CITY OF ALBUQUERQUE

Re: Beehive Homes – Phase 2
13450 Wenonah Ave., SE
Request for Certificate of Occupancy- Transportation Development
Engineer's/Architect's Stamp dated 10-1-13 (L23-D022)
Amended Plan Stamp date 7-31-14
Certification dated 2-19-16

WHEELCHAIR RAMP DETAIL (TYP.)
NTS

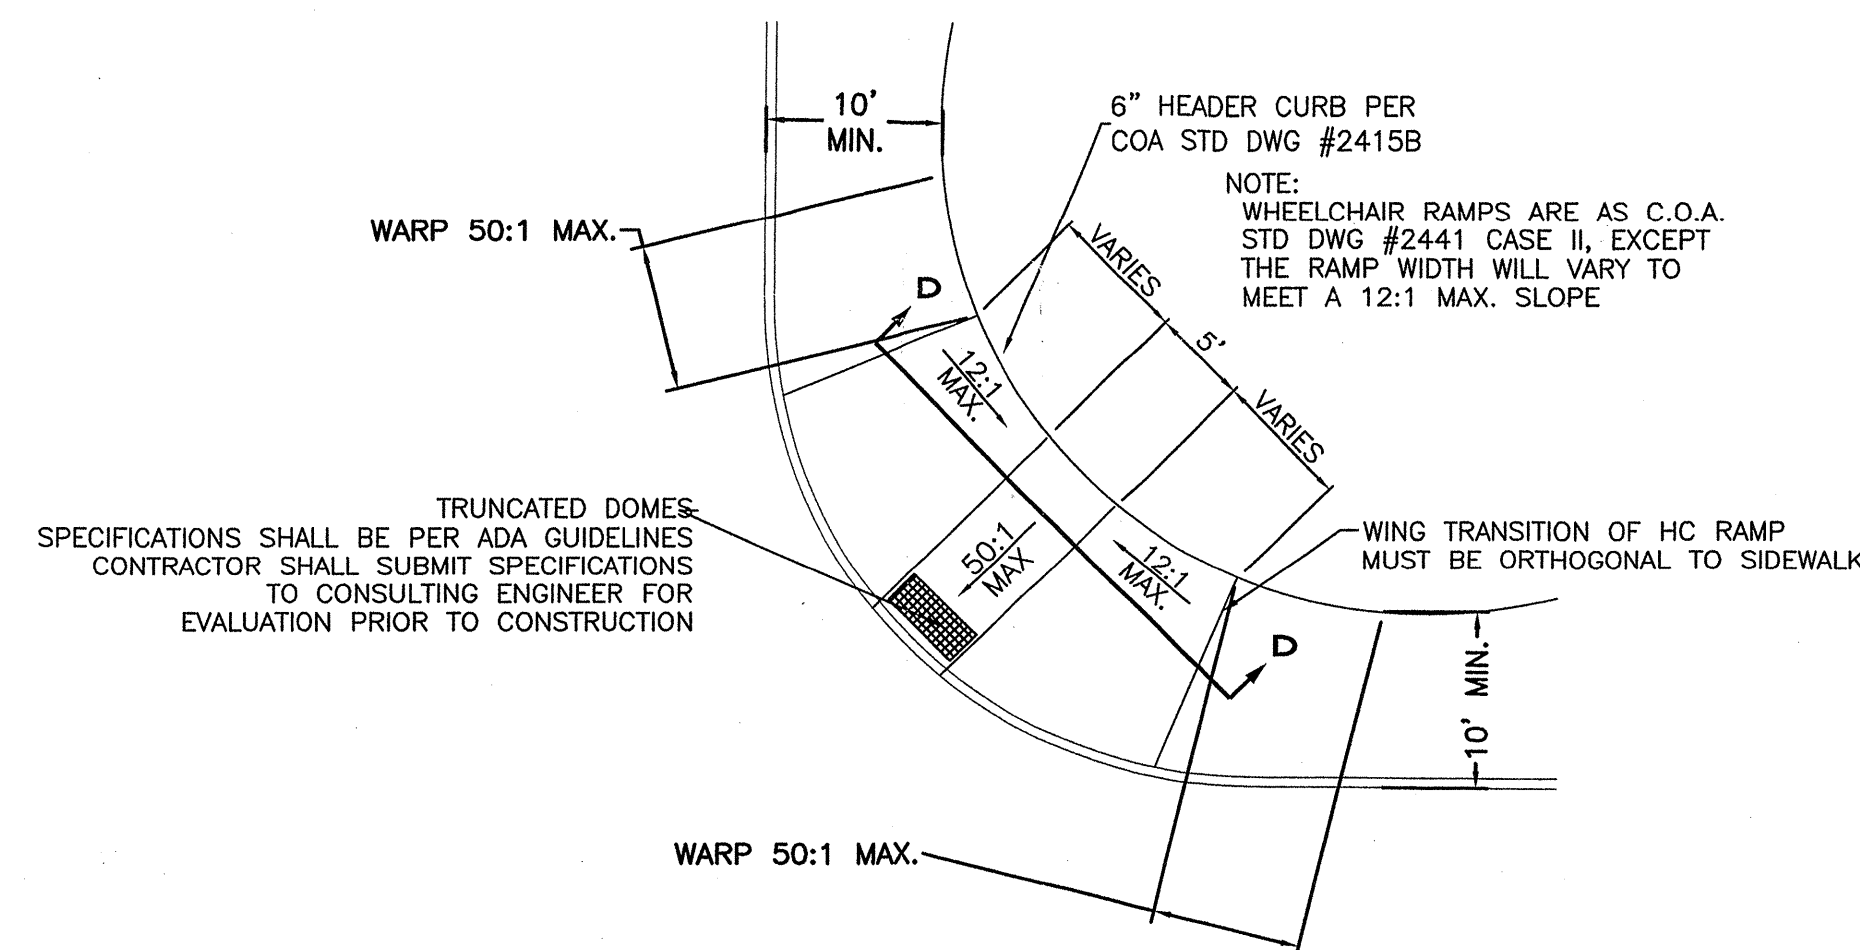
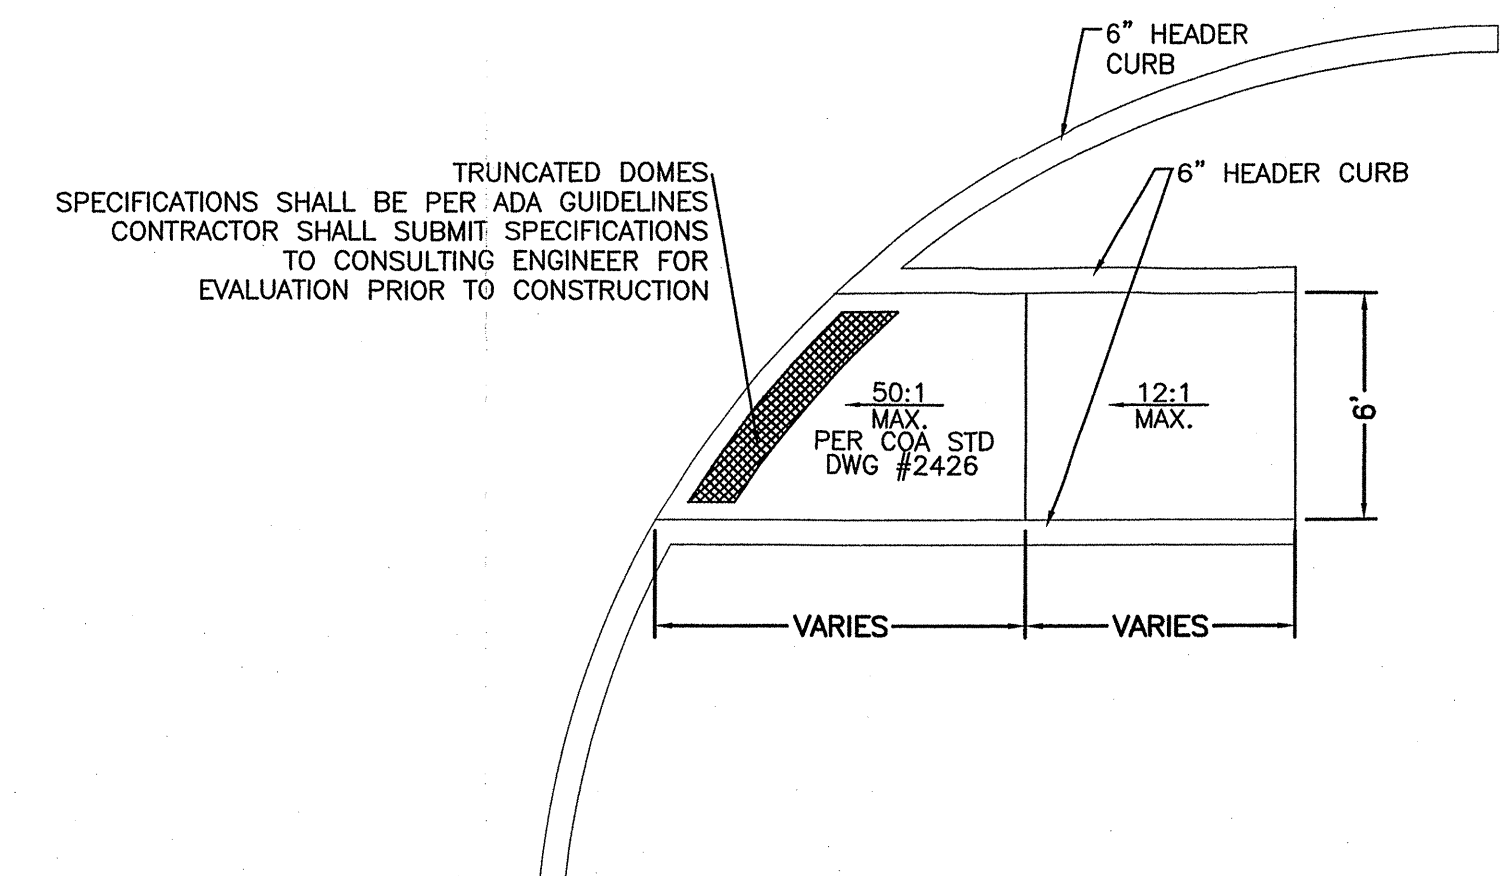
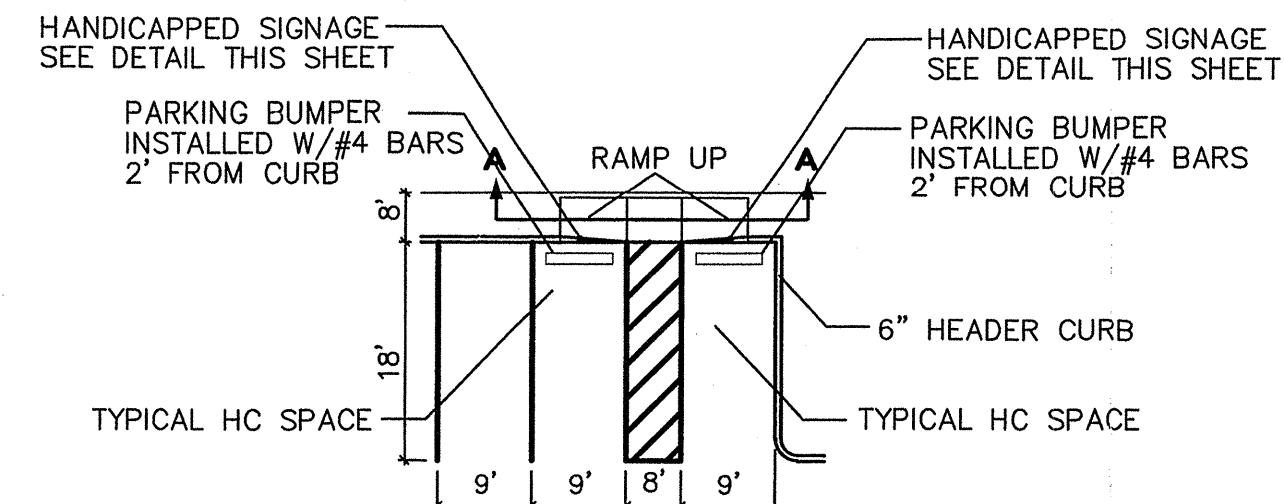
- As approved on the TCL BP Drawing dated 7-31-14, the ADA ramps at the access isle between the HC parking spaces west of Bldg. No. 1 must be reconstructed to meet ADA requirements. It is not permissible to have the ADA access isle located and guiding pedestrians behind parked vehicles, as built.
- The ADA accessible parking sign must have the required language per 66-7-352.4C NMSA 1978 **"Violators Are Subject to a Fine and/or Towing"**.
